Former Nestle Factory, Hayes – Ref: 1331/APP/2017/1883

Conservation & Design Advice – Schedule One

Barratt London & SEGRO Design Team Response

**FORMER NESTLE FACTORY, HAYES**  
ILLUSTRATIVE ELEVATIONS UNIT 2&3  
SCALE 1:200 @ A1

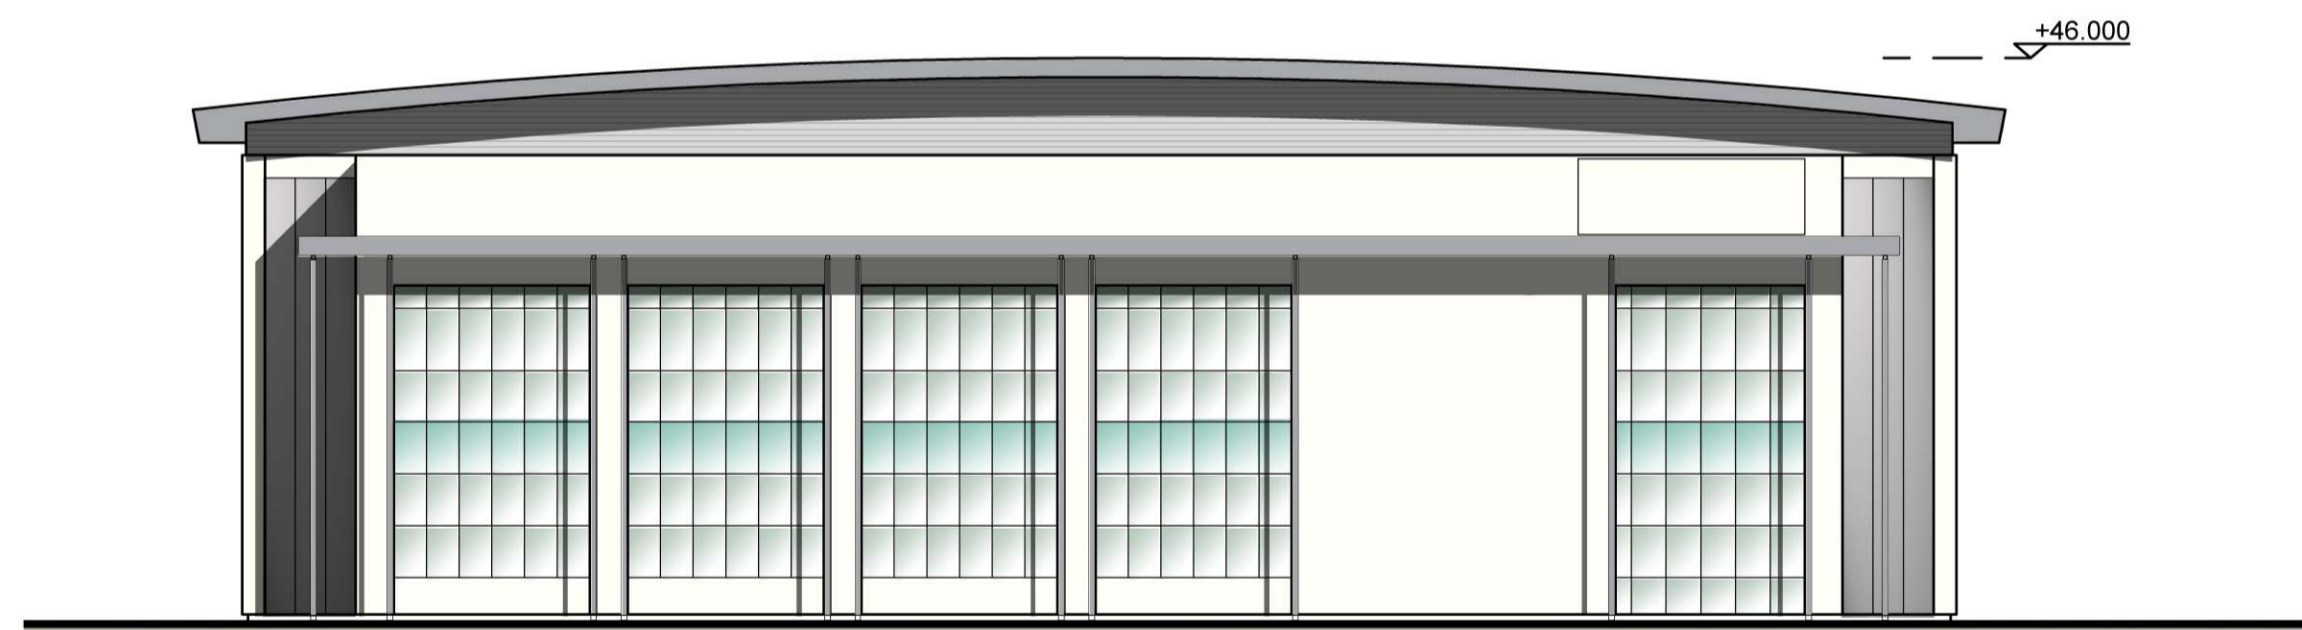
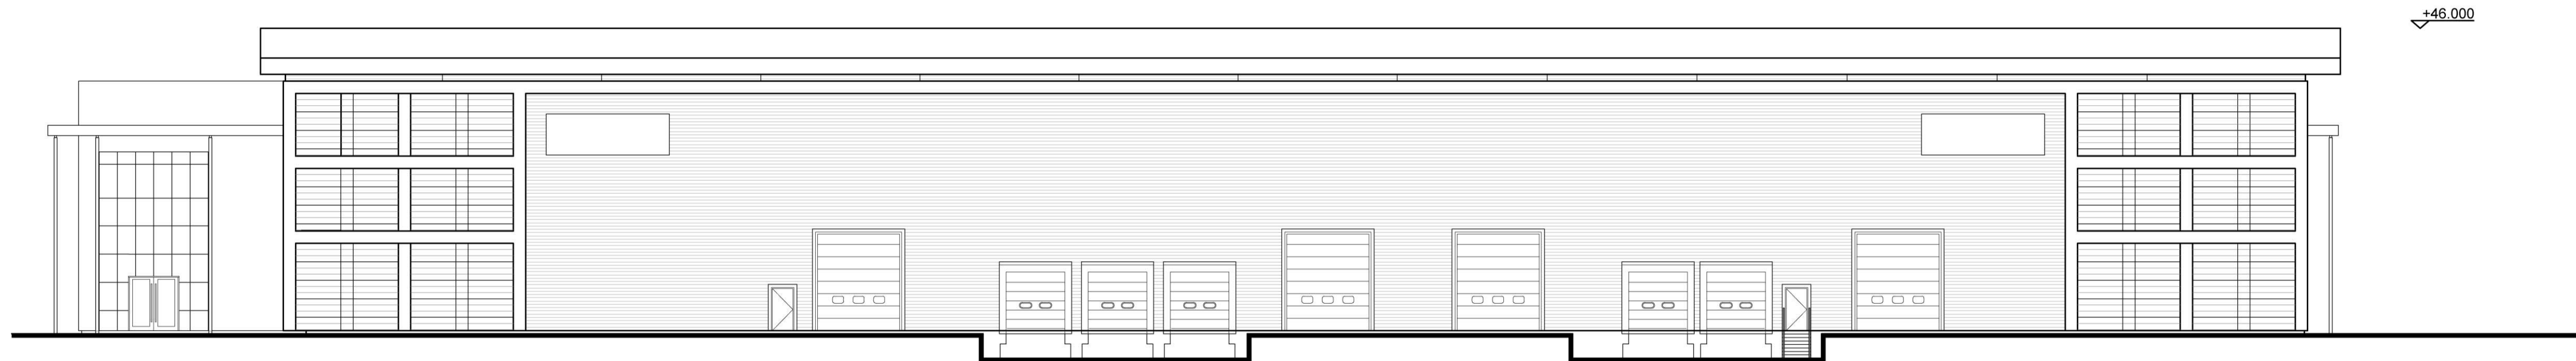
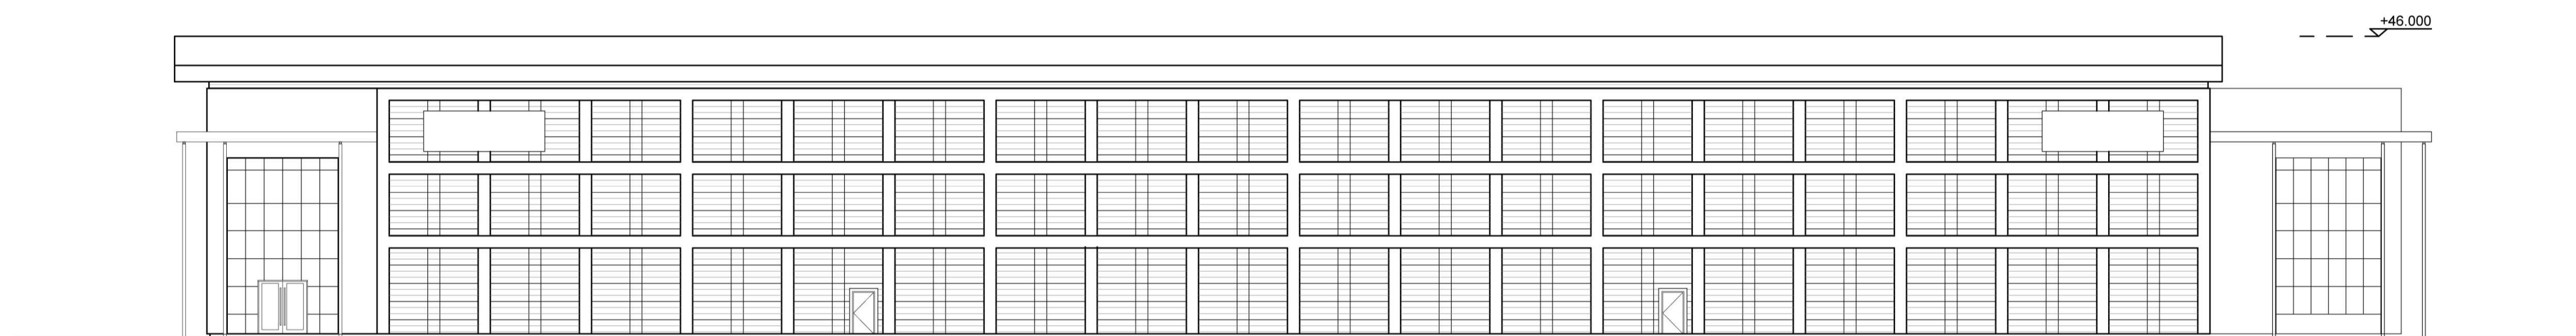
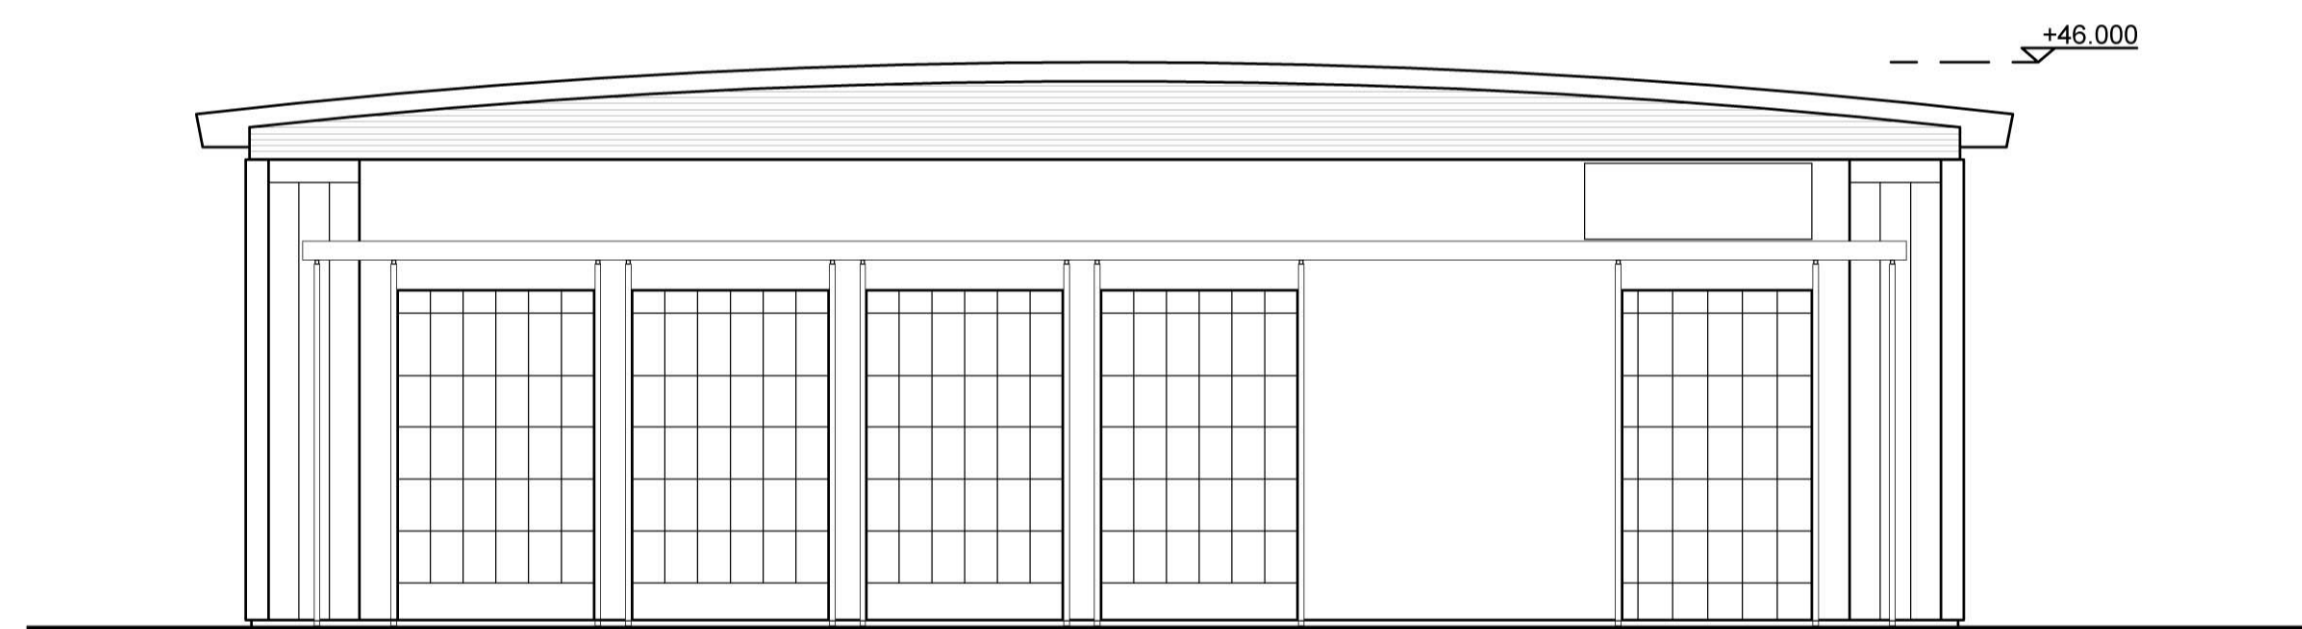
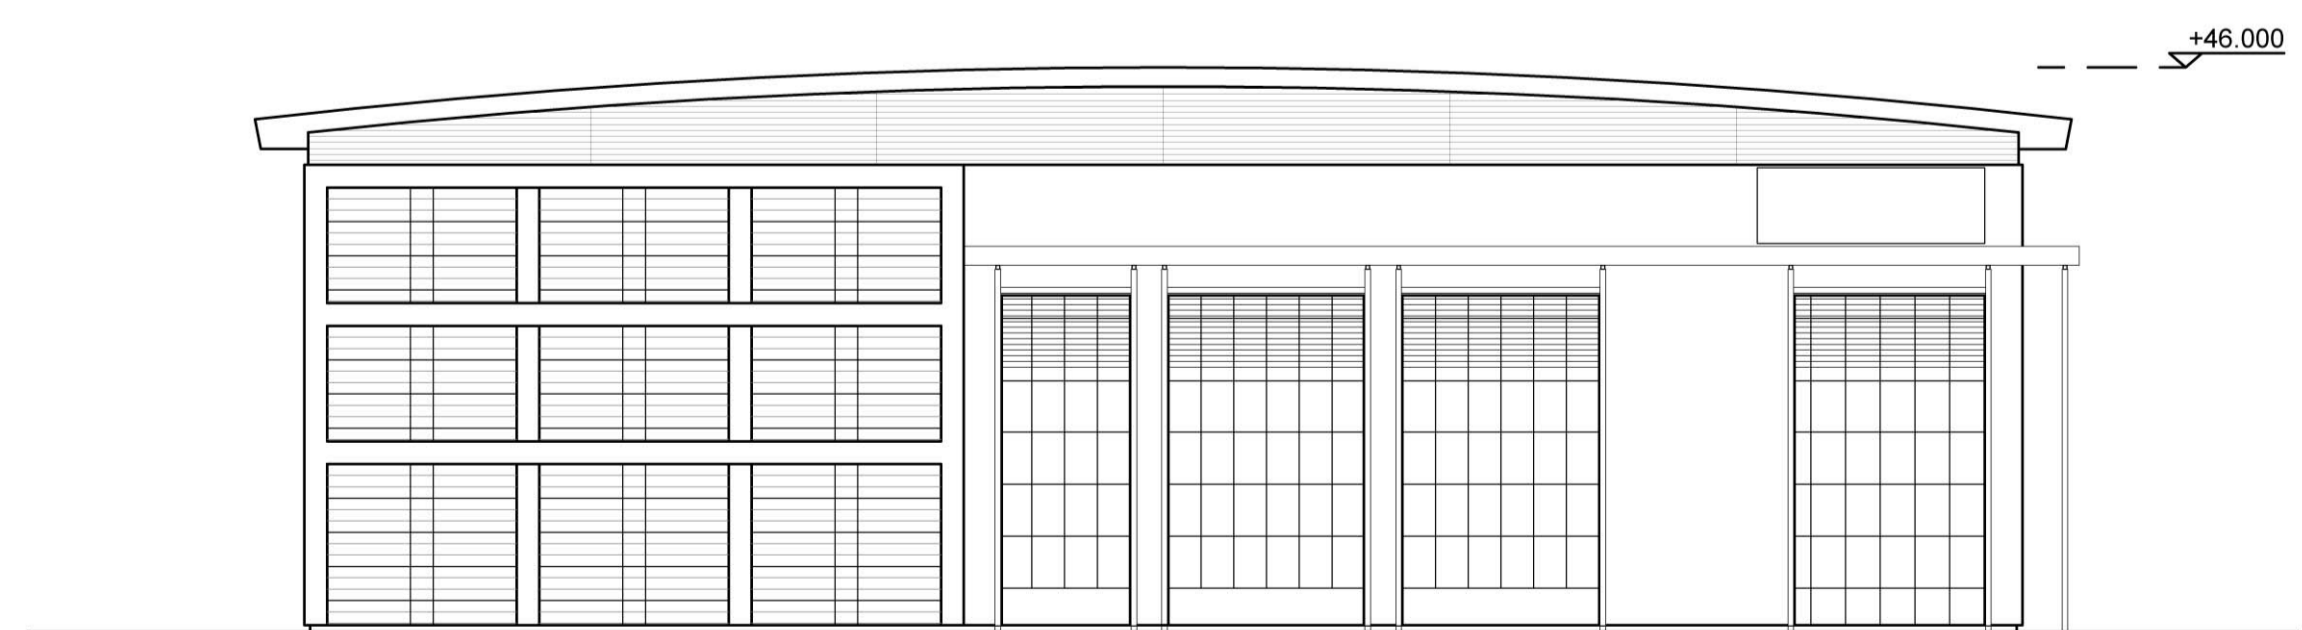
32.	Unit 1 needs a better detailed elevation onto Nestle Avenue, a green wall? The northern elevation of unit 3 needs to look more like unit 1 and relate better to the original factory design. All of the units should have green roofs.	Response to follow.
